Shell, Stanborough Road,  
Welwyn Garden City

Project Reference: 2109-023/TN/01

Technical Note

## 1 Response to highways comments

TITLE: PROPOSED SITE LAYOUT - 1:100

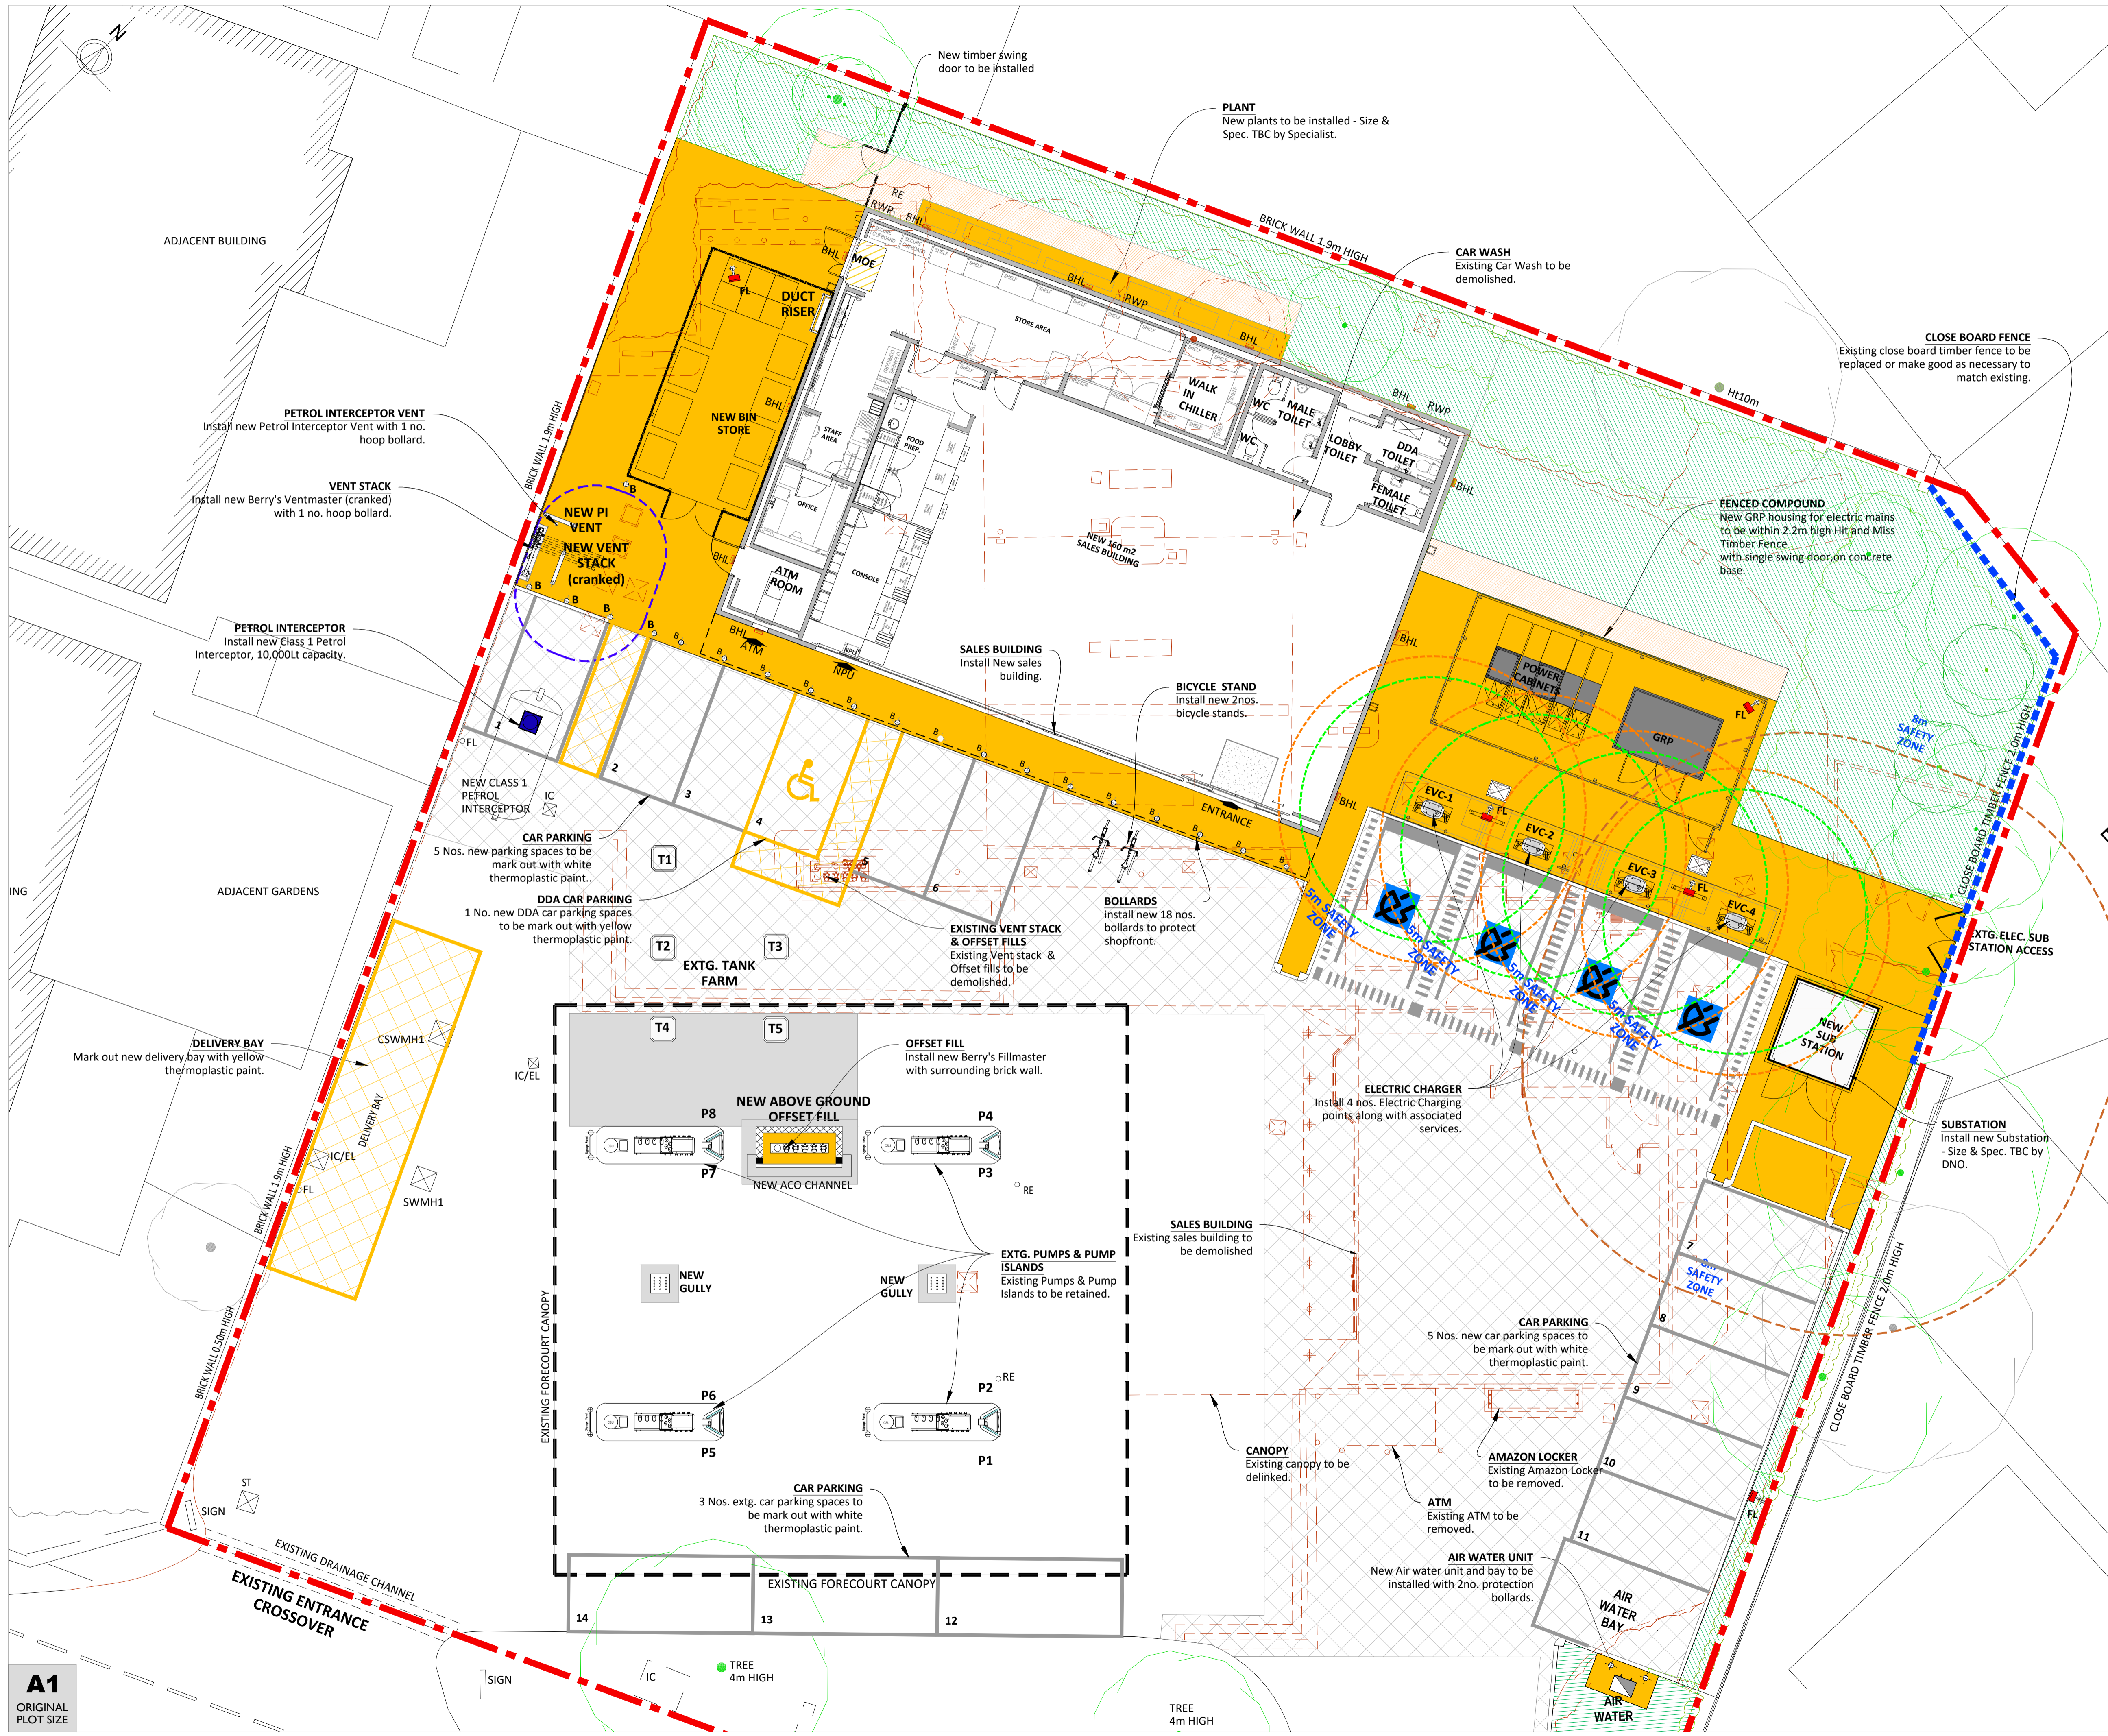
- 1.2 The comments request that the vehicular access points for the site are either narrowed and tactile paving included or that they are changed to dropped kerb type accesses. The latter solution would not be viable without changing the level of the forecourt within the site and as such a design has been produced for narrowing of the accesses and the inclusion of tactile paving. A plan illustrating the proposed arrangement is appended to this report.

- 1.3 A further comment was received with regard to access between the bin storage on site and a refuse vehicle. The updated scheme now includes a 1.5m gap between the parking bays, allowing for bins to be taken to and from a refuse vehicle.

TITLE: PROPOSED SITE LAYOUT - 1:200

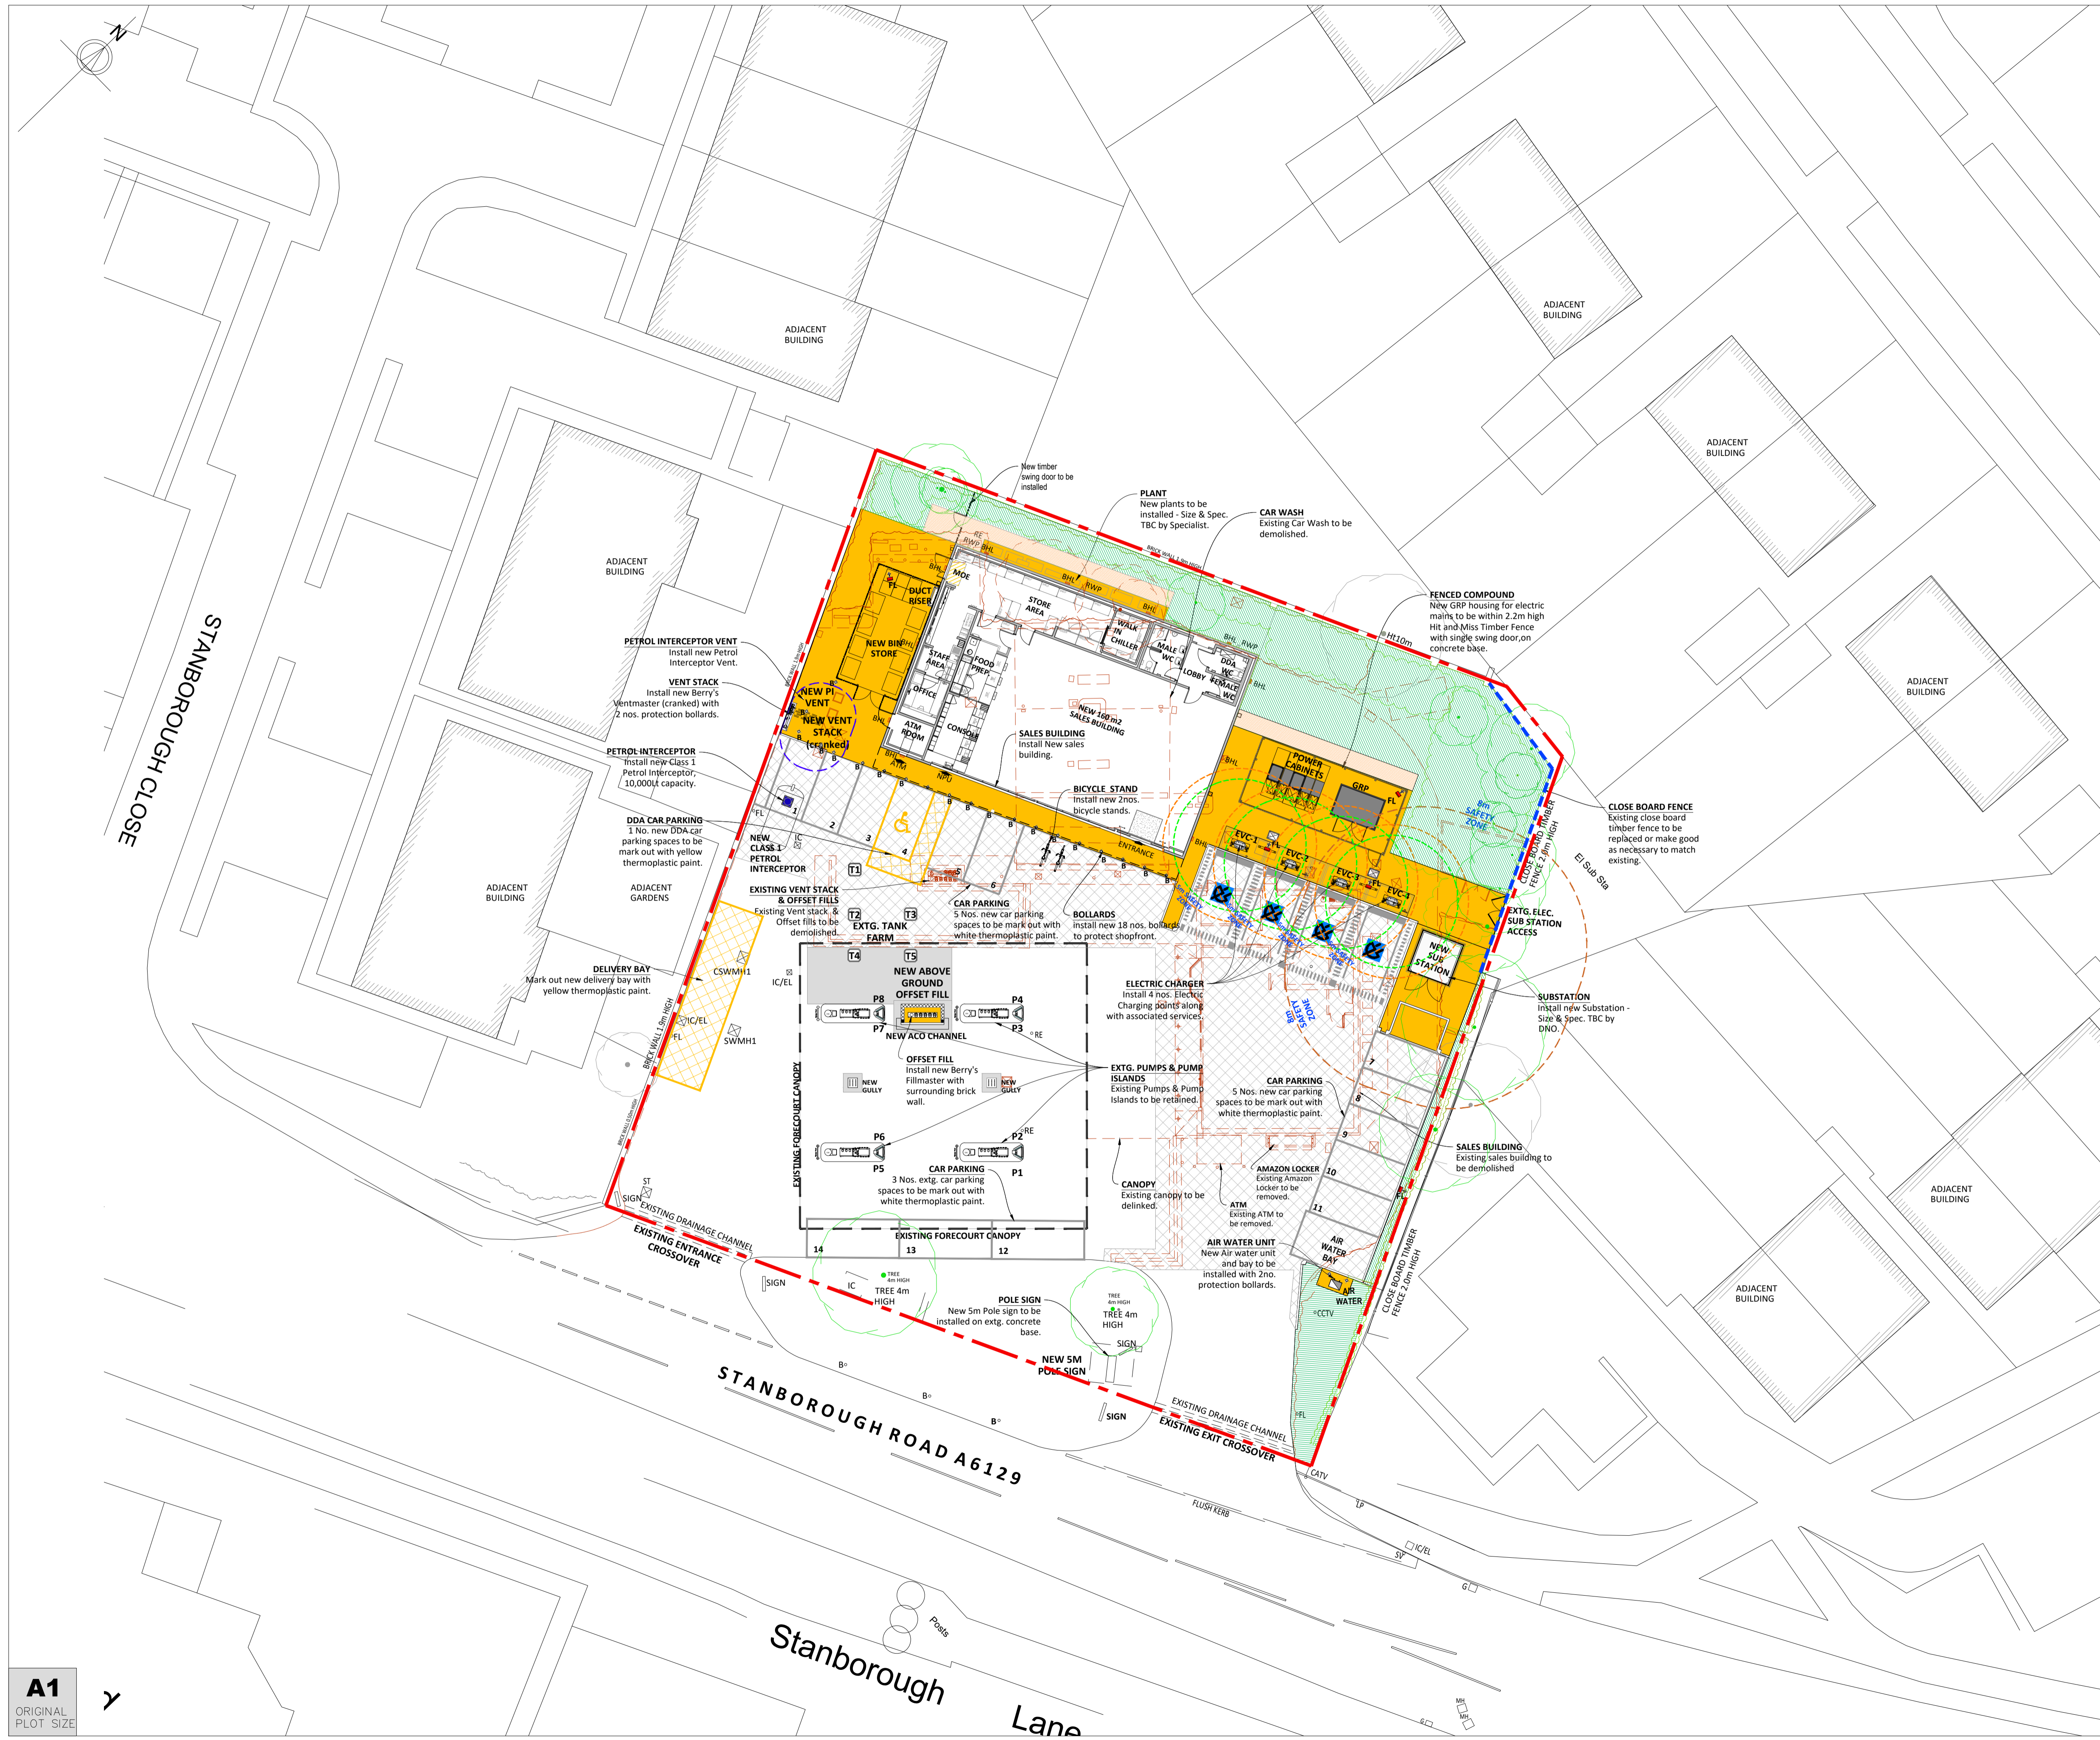
- 1.4 Swept path analysis for refuse vehicles, goods delivery vehicles (which are expected to be 10m rigid vehicles or smaller) and for 16.5m articulated vehicles is provided on the appended plans, highlighting that all vehicles will be able to enter and exit the site in forward gear, following the entry only / exit only arrangement set out for the two access points.
